Appeal Decision

Appeal Ref: APP/R5510/D/22/3311878

231 Long Lane, Hillingdon, Uxbridge UB10 9JP

- The appeal is made under section 78 of the Town and Country Planning Act 1990 against a refusal to grant approval required under Schedule 2, Part 1, Class AA of the Town and Country Planning (General Permitted Development) (England) Order 2015 (as amended).
- The appeal is made by Mark Baldwin (plansdesigned) against the decision of the council of the London Borough of Hillingdon.
- The application Ref 65967/APP/2022/2863, dated 16 September 2022, was refused by notice dated 9 November 2022.
- The development proposed is for the erection of two additional storeys.

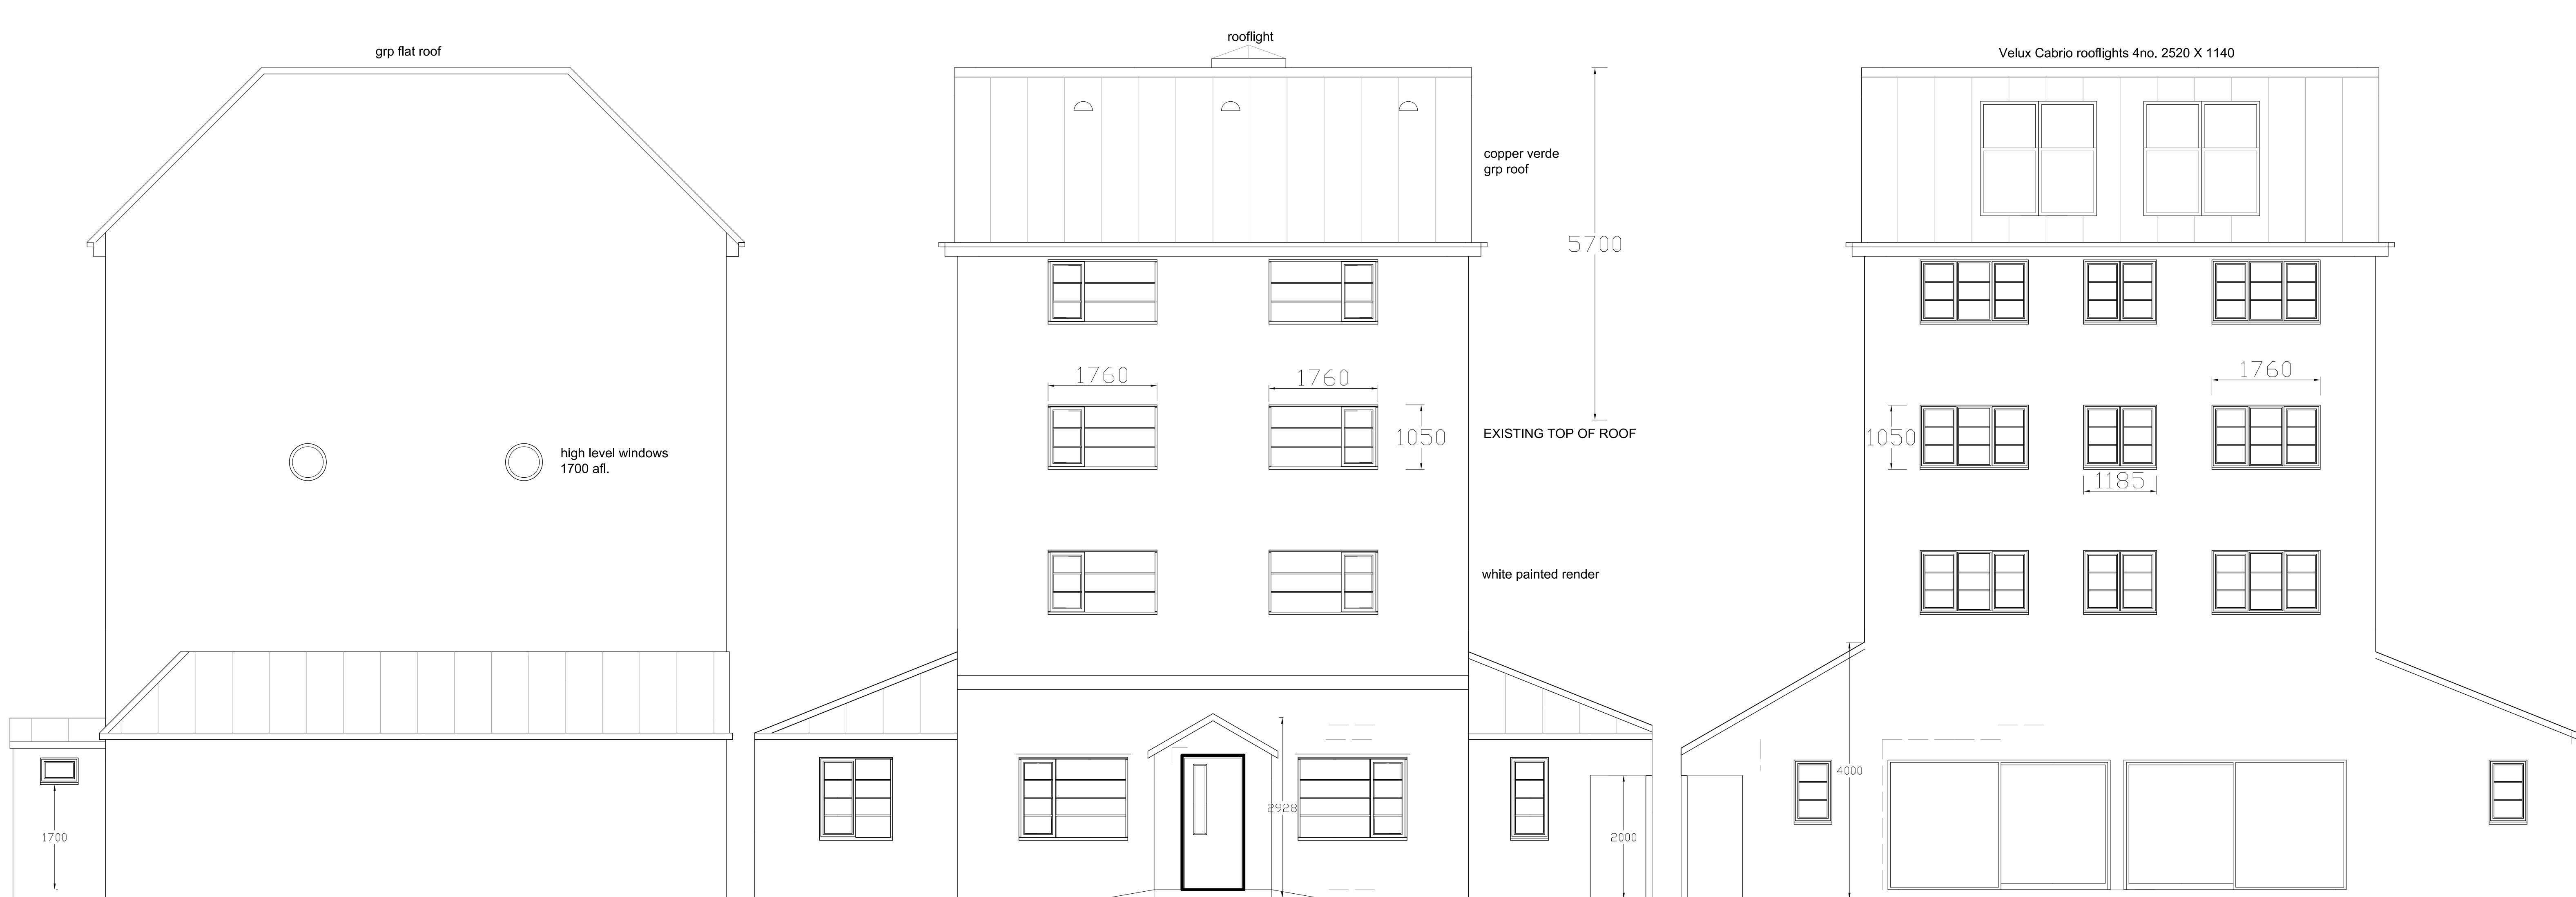
5. There is a first floor window in the side elevation of No 229 which is already in close proximity to the corresponding side elevation of the appeal building. Whilst this relationship does have a reducing effect on the amount of light into that window and some of the garden space to the side and immediate rear of No 229, the substantial additional height of the resulting building would exacerbate the situation, as well as increasing the amount of time during the day when the space served by said window, and areas of the garden of No 229 closest to the resulting building, would lack natural light. This would be harmful to the living conditions of the occupiers of No 229, unacceptably reducing the quality of the experience of the concerned spaces.

8. The scheme would add two whole new storeys to the building and whilst material would be repeated, the overall height specifically would make the building appear anomalous in the street scene, unacceptably reducing the quality of its consistency. As such, the design and architectural features of the relevant elevations would not be acceptable.
